December 2, 2016

SUBJECT: **Modification Request of Section 404 Regional General Permit No. 31 and Section 401 General Water Quality Certification No. 3886** for the proposed Interstate 85 (I-85) Widening and Interchange Improvements from north of NC 73 (Davidson Highway / Exit 55) to north of SR 2180 (Lane Street/Exit 63), Cabarrus & Rowan Counties, Divisions 9 and 10. Federal Aid Project No. FANHIMF-085-2(61)55, TIP Project No. I-3802A.

The permit drawings for these three sites have been revised to depict the additional bank stabilization at Site 2, temporary impacts at Site UC-1, and the additional bank stabilization at Site 18. They have been included in this modification request along with the revised impact summary tables.

PROJECT REFERENCE NO. I-3802A	SHEET NO. 6A
R/W SHEET NO.	
ROADWAY DESIGN ENGINEER	HYDRAULICS ENGINEER
BLYTHE

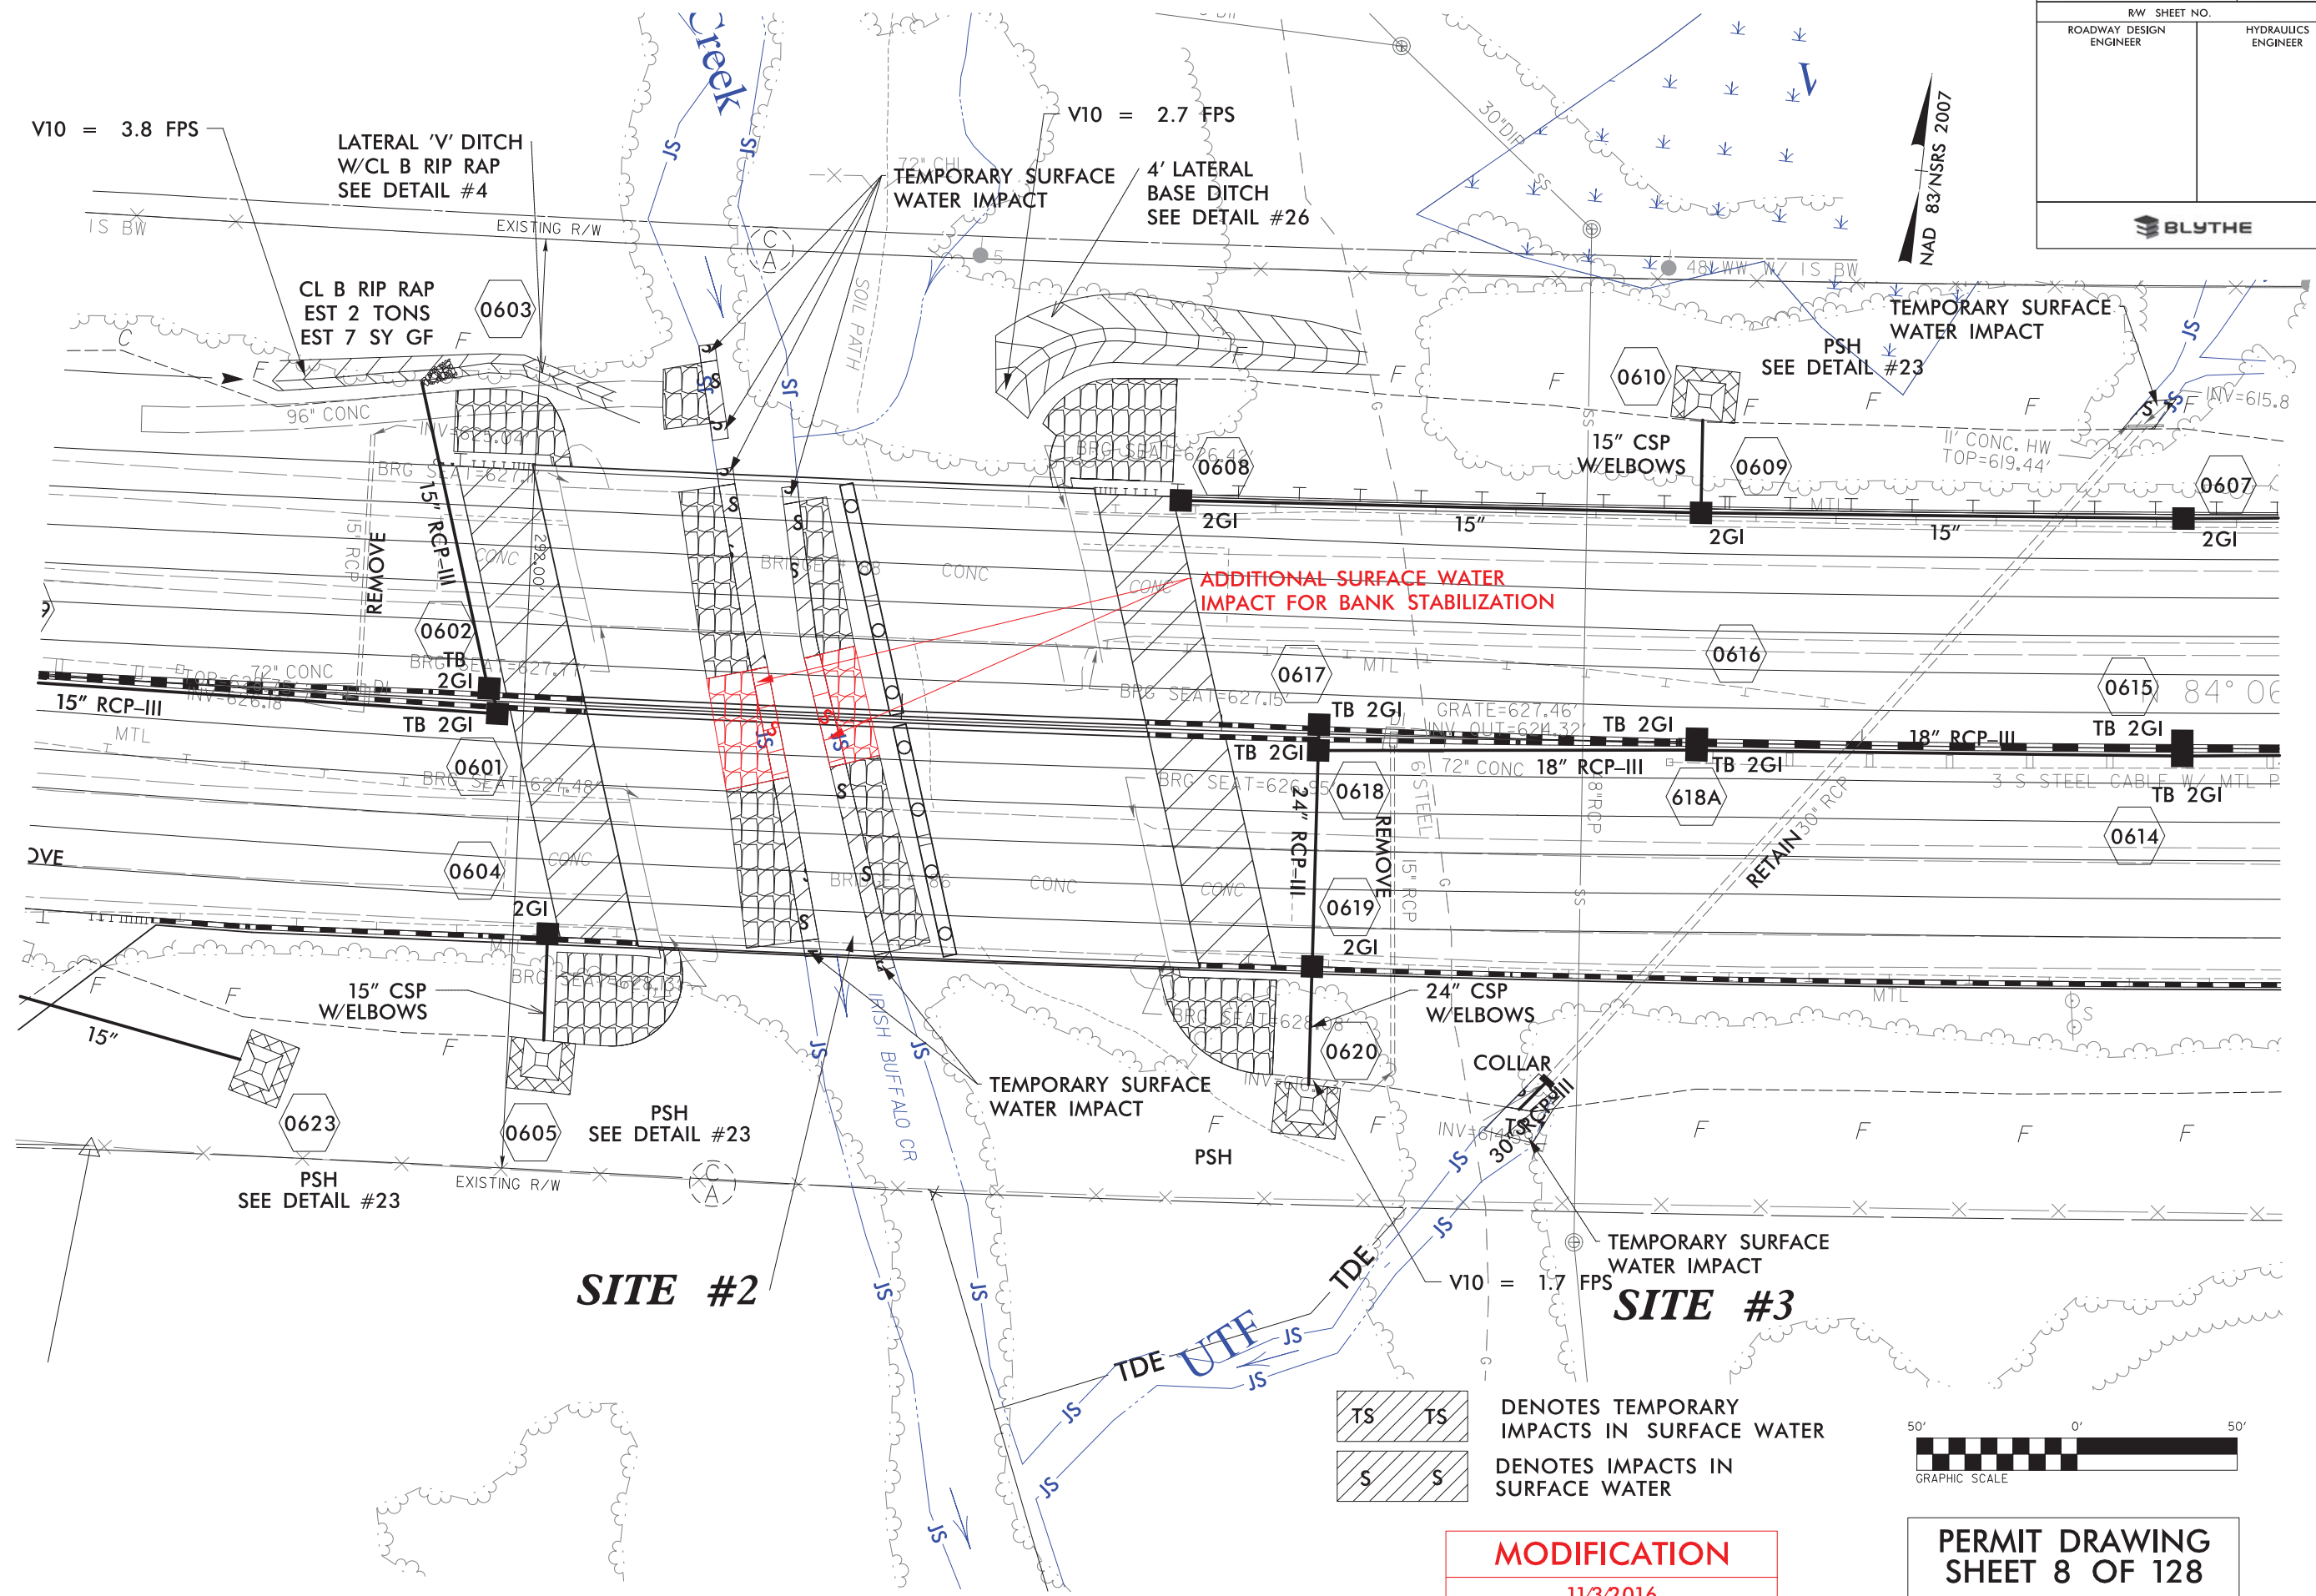
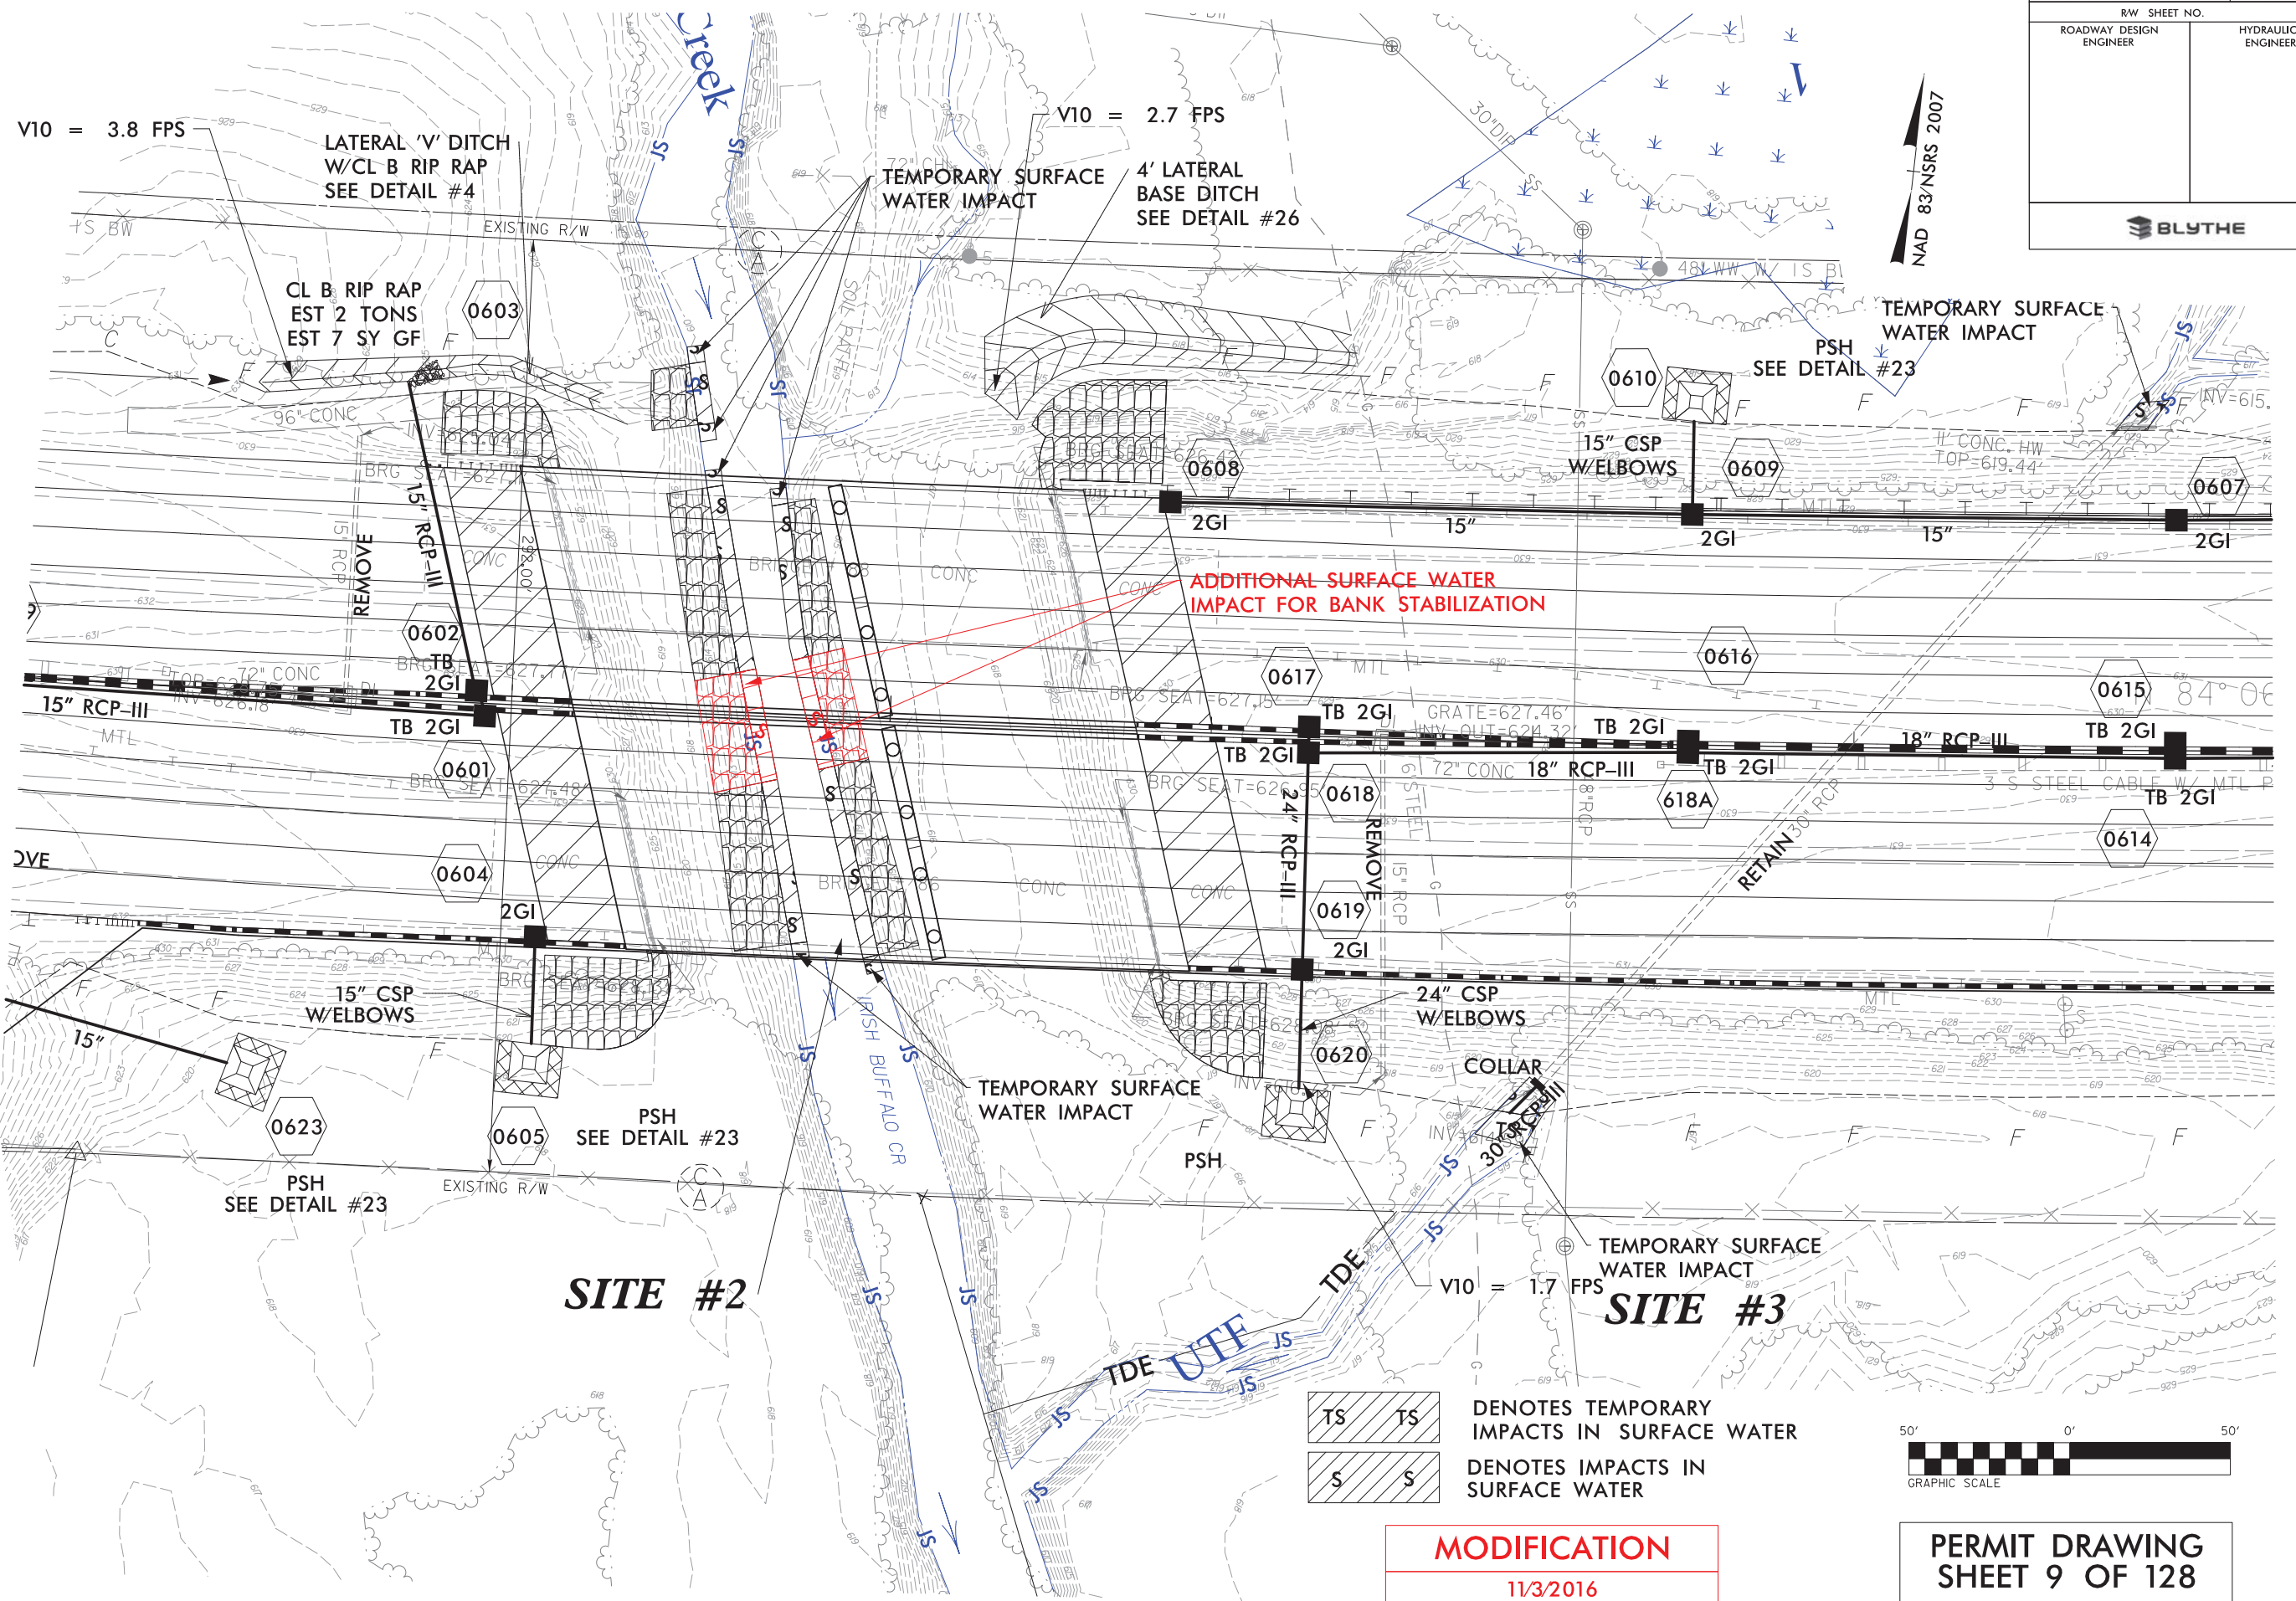
During the same field review for Site 18 on November 17, 2015, Ms. Hood requested that additional riprap be placed on the banks of Irish Buffalo Creek under the existing bridge to prevent erosion from existing shading and potential vegetation die-off. As a result, Class II riprap is being proposed at this location with geotextile fabric to be installed between the Class II riprap and the stream bed and stream banks.

Previous Site 2 impacts included 30 linear feet of temporary stream impacts and 137 linear feet of bank stabilization impacts. The additional bank stabilization at Site 2 will result in an additional 35 linear feet of permanent bank stabilization impact. Consequently, the proposed overall total for Site 2, including the previously-permitted impacts and currently proposed impacts will be 20 linear feet of temporary impacts and 172 linear feet of bank stabilization impacts. As a result of the currently proposed bank stabilization, temporary impacts at Site 2 will decrease from the permitted total of 30 linear feet to 20 linear feet due to the elimination of two 5 linear foot sections of temporary impact. No other changes to permitted wetland and stream impact are proposed for Site 2.
